Stage 1B Basement (SSD 15_6960)

Detailed Response to Submissions Addendum – TfNSW Submission

Figure 10 Site Access Diagram

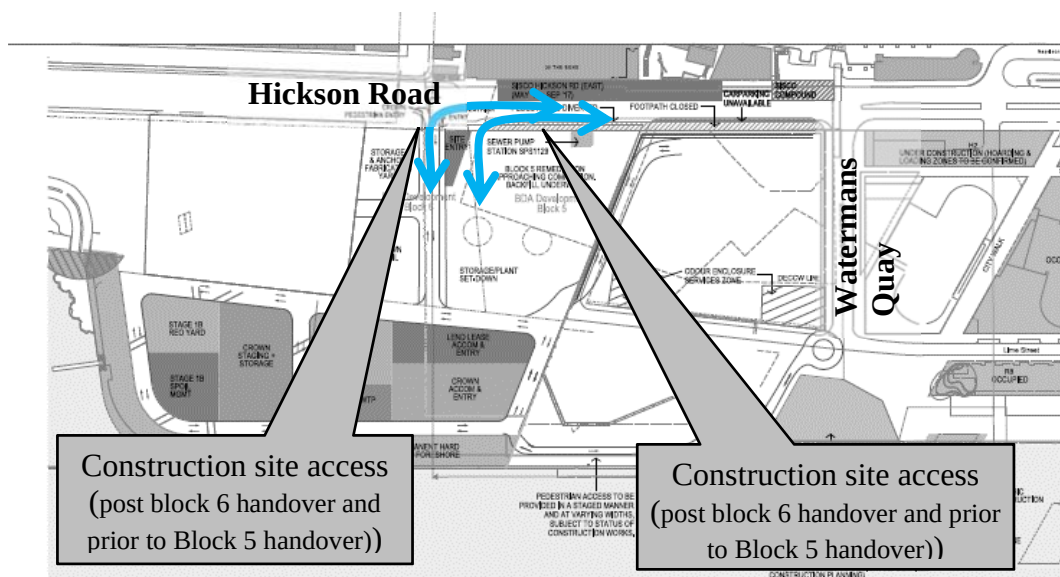
<u>Figure 8 (Section 4.7) of the TMAP — Site Access Diagram</u> It is noted that notations for both proposed construction accesses are same. TfNSW requests that the applicant confirm these notations are correct.	This notations have been amended in the updated report submitted with the Stage 1B Basement Response to Submissions.
	<u>Section 5.2 of the TMAP — Basement Access Arrangements</u> The following comments are provided in relation to the basement access arrangements. - The TMAP states that by mid-2015, the Hickson Road/Napoleon Street/Sussex Street intersection will be signalised to provide egress from the basement car park. TfNSW advises that the Hickson Road/Napoleon Street/Sussex Street intersection has already been signalised	Noted, the report submitted with the Stage 1B Basement Response to Submissions has been updated to reflect the signalisation of this intersection.
